# CITY OF ALBUQUERQUE

August 19, 2019

**RE: Academy Parkway Self-Storage  
3605 Osuna Rd. NW  
Grading and Drainage Plan  
Engineer's Stamp Date: 08/05/19  
Hydrology File: E17D001W**

Based upon the information provided in your submittal received 08/06/2019, the Grading & Drainage Plan **is not** approved for Building Permit. The following comments need to be addressed for approval of the above referenced project:

C-2

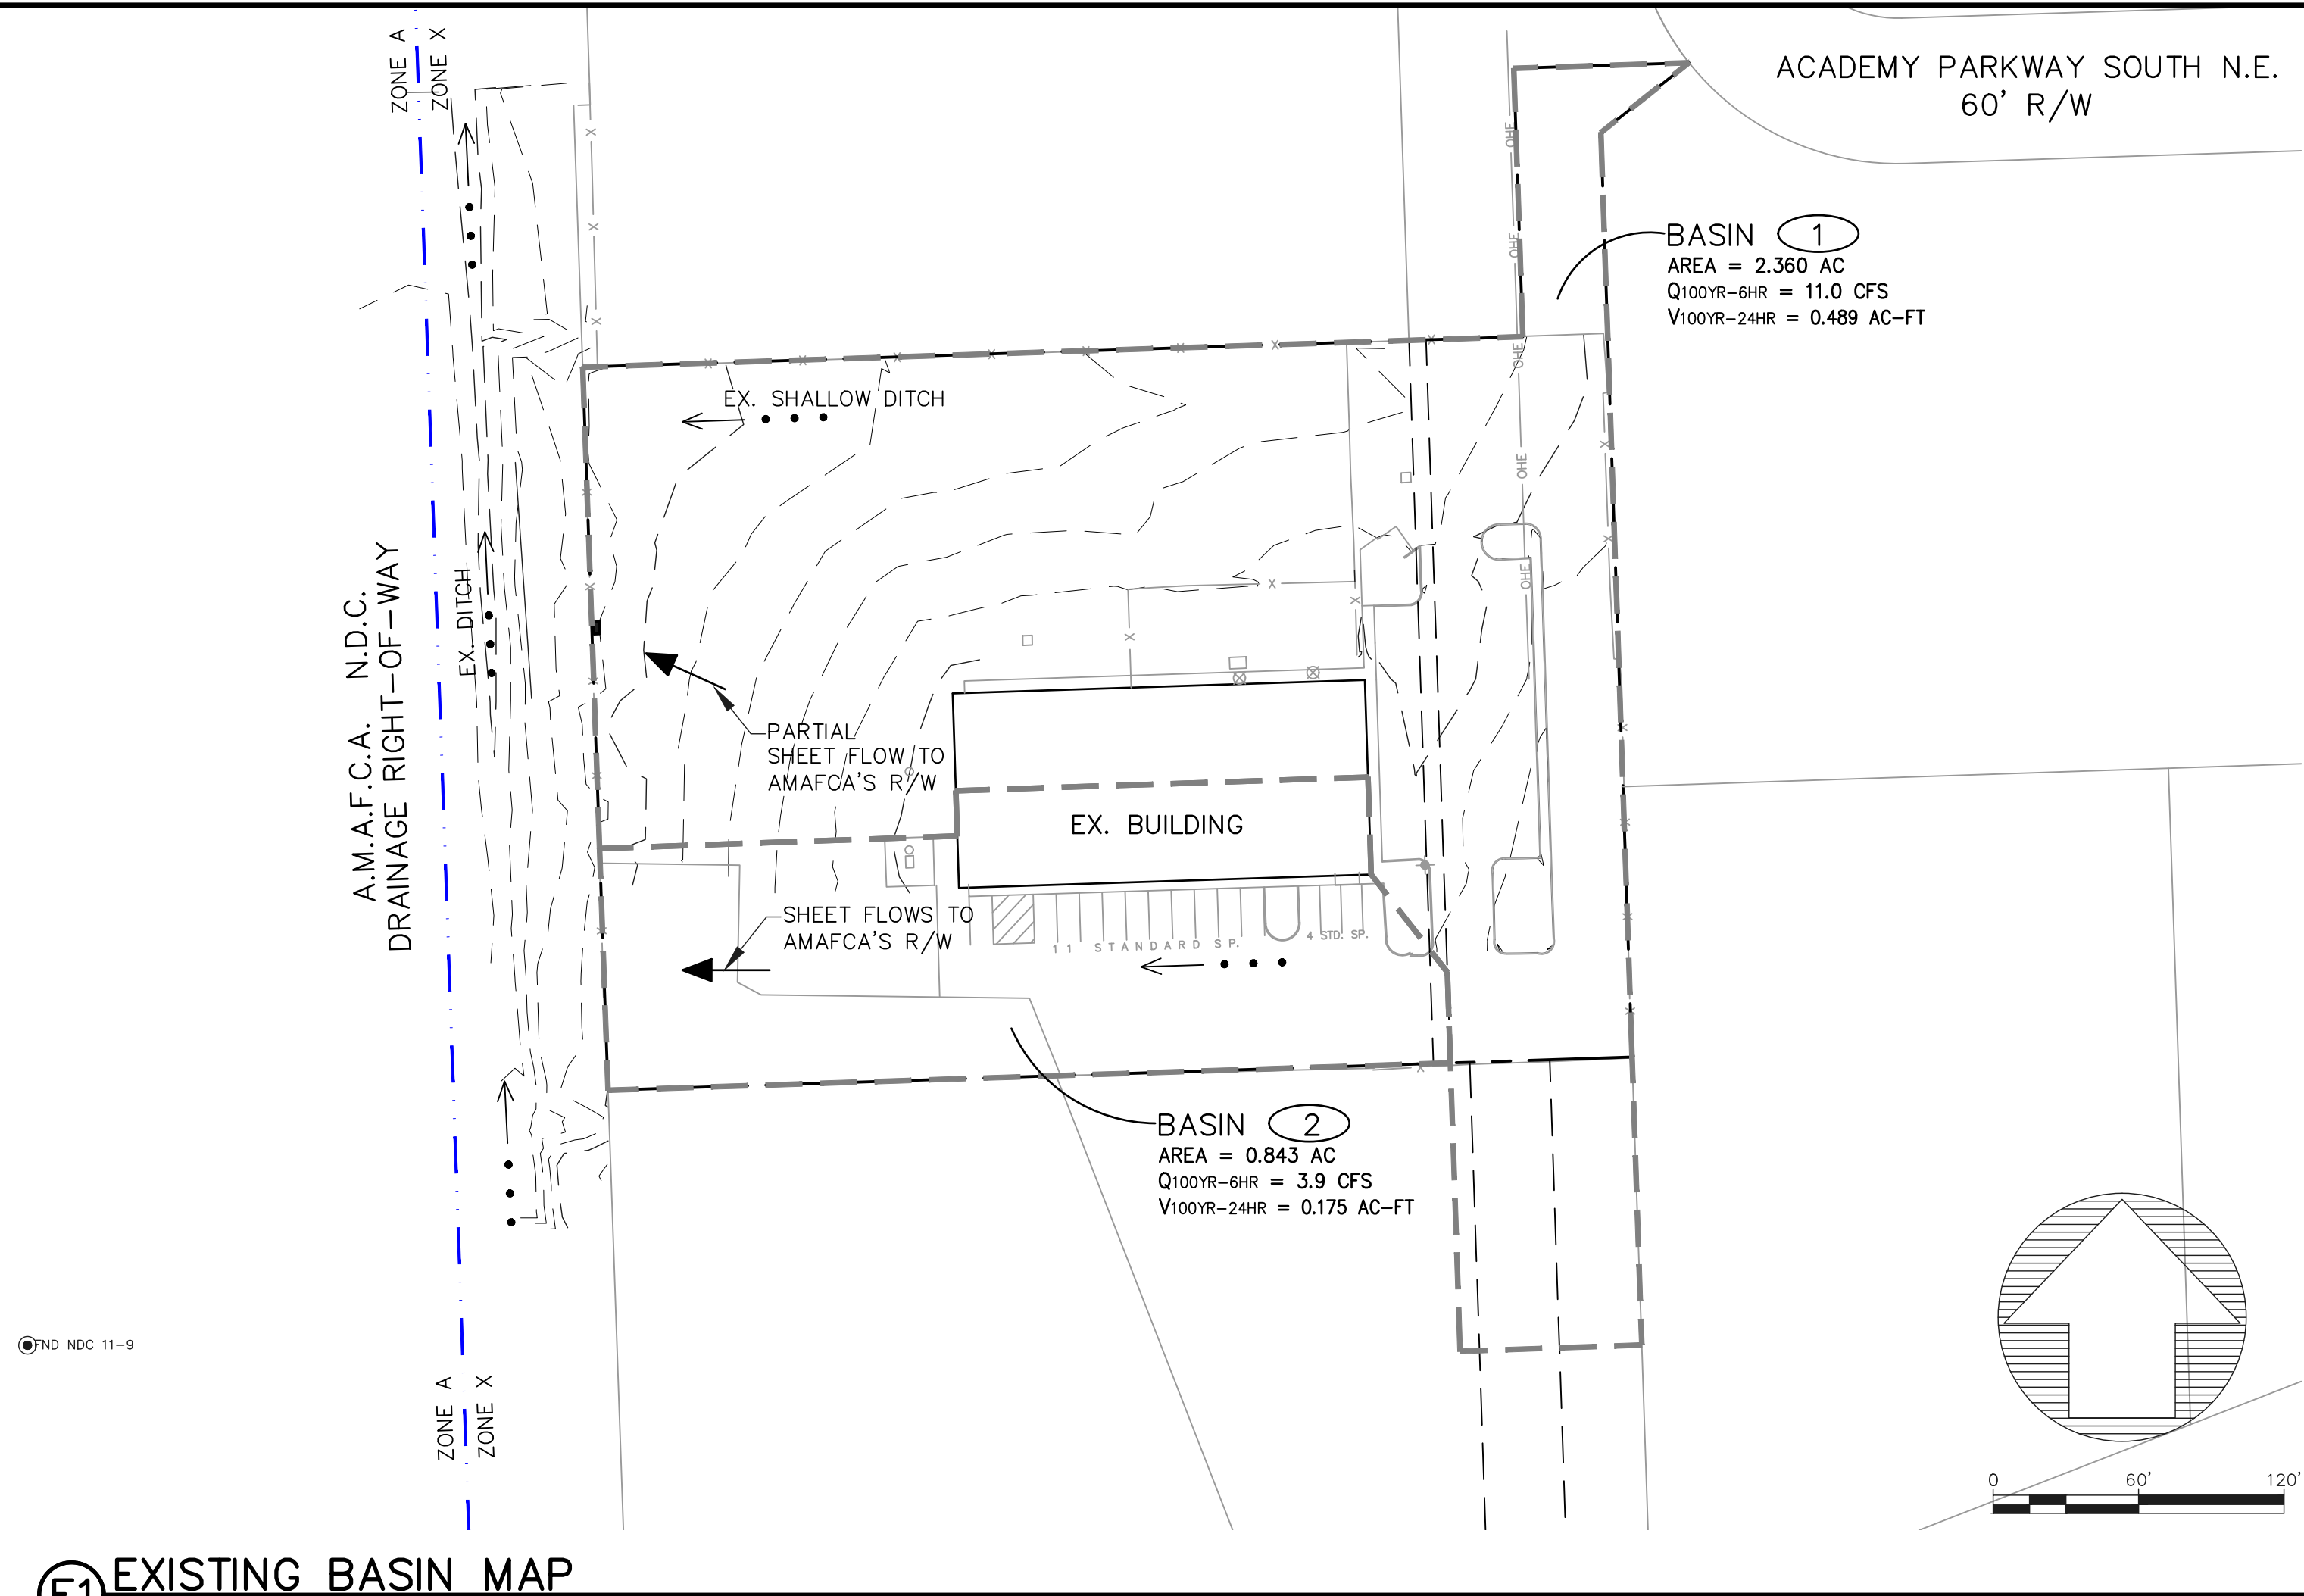
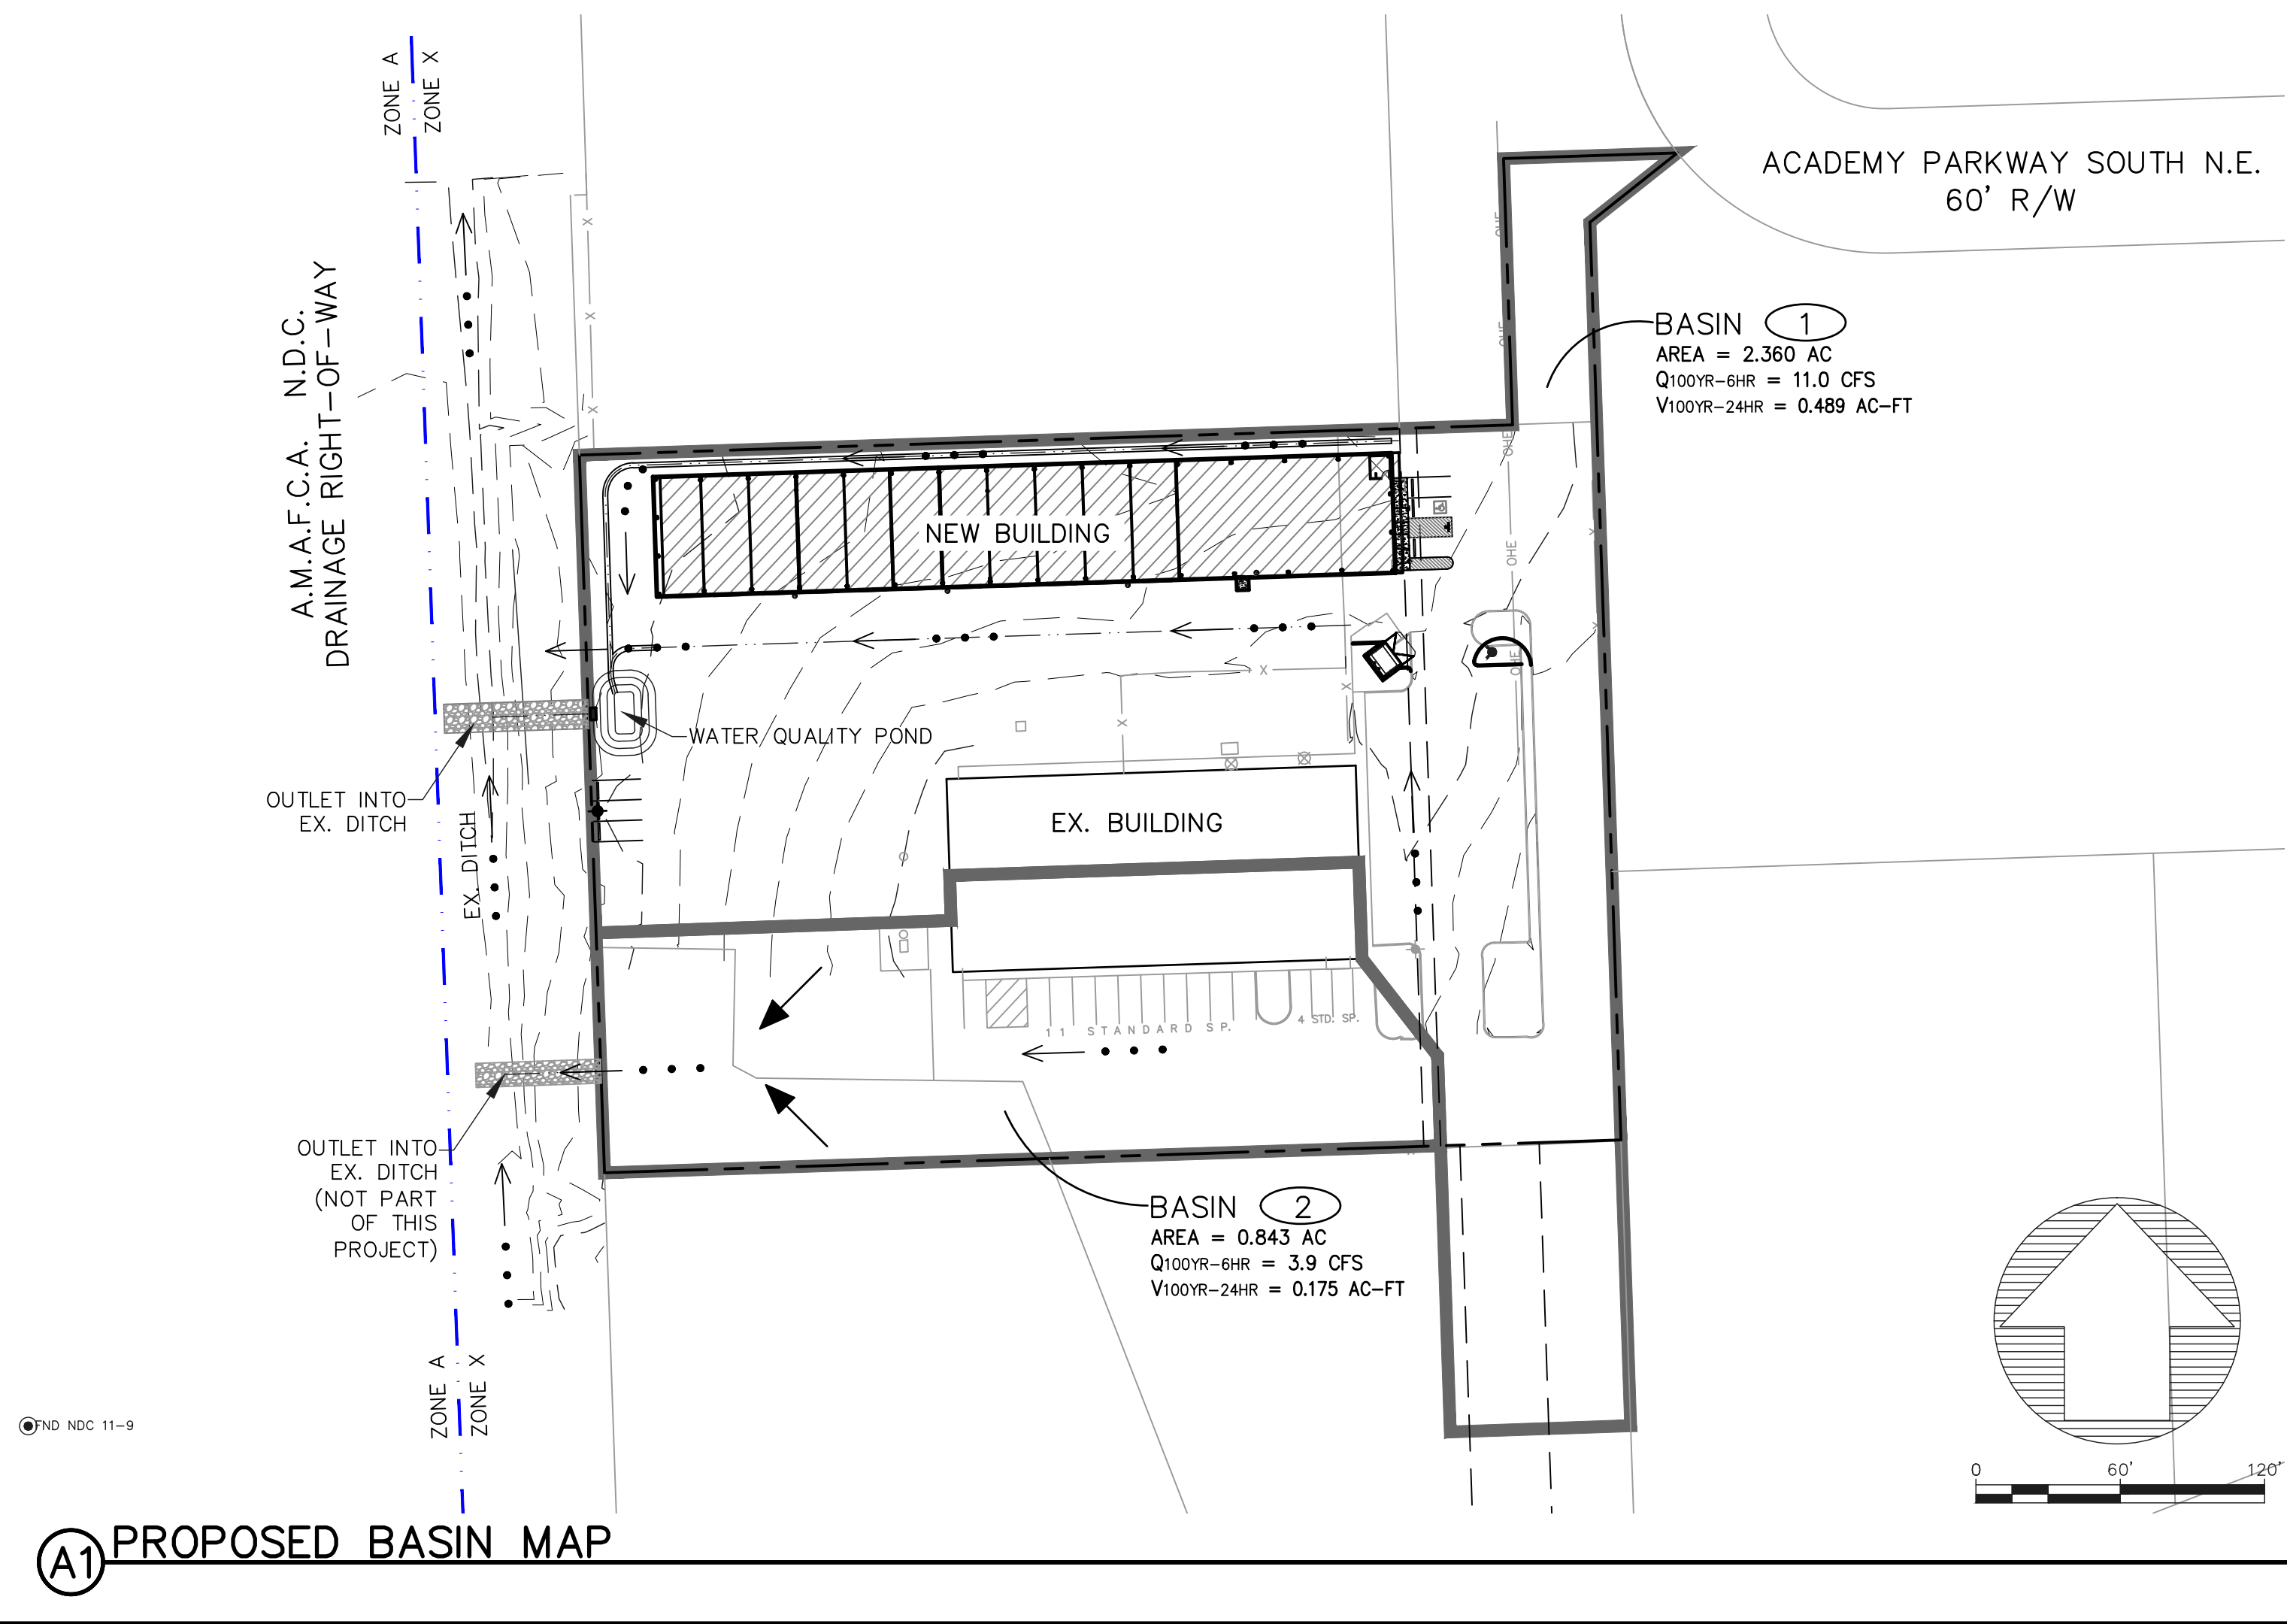
1. Since this project is adjacent to, or drains into an Albuquerque Metropolitan Arroyo and Flood Control Authority (AMAFCA) facility, approval by AMAFCA will be need prior to Hydrology approval. Please contact Nicole Friedt P.E, CFM ([nfriedt@amafca.org](mailto:nfriedt@amafca.org) or 505-884-2215).
2. Please show the Floodplain Zone "A" within the AMAFCA's North Diversion Channel on both sheets.
3. Please label AMAFCA's North Diversion Channel on both sheets.
4. Sheet C-1. Please show the stormwater quality ponds per AMAFCA's email dated 8/19/19.
5. Sheet C-1. Please remove the SO-19 Notes and replace with a note stating, "Coordinate with AMAFCA at (505) xxx-xxxx 48 hours prior to work within AMAFCA's North Diversion Channel." Please contact Nicole at AMAFCA for the contact person and number.
6. Sheet C-2. Please label "Academy Parkway S. NE" on both Basin Maps.

7. Sheet C-2 under Proposed Conditions. Since AMFCA is requiring the stormwater quality ponds please remove the line "The Owner will pay fee in lieu instead of retaining the first flush volume".

8. Sheet C-2 Proposed Basin Map. Please show the stormwater quality ponds per AMAFCA's email dated 8/19/19.
9. As a reminder, if the project total area of disturbance (including the staging area and any work within the adjacent Right-of-Way) is 1 acre or more, then an Erosion and Sediment Control (ESC) Plan and Owner's certified Notice of Intent (NOI) is required to be submitted to the Stormwater Quality Engineer (Dough Hughes, PE, [jhughes@cabq.gov](mailto:jhughes@cabq.gov), 924-3420) 14 days prior to any earth disturbance.
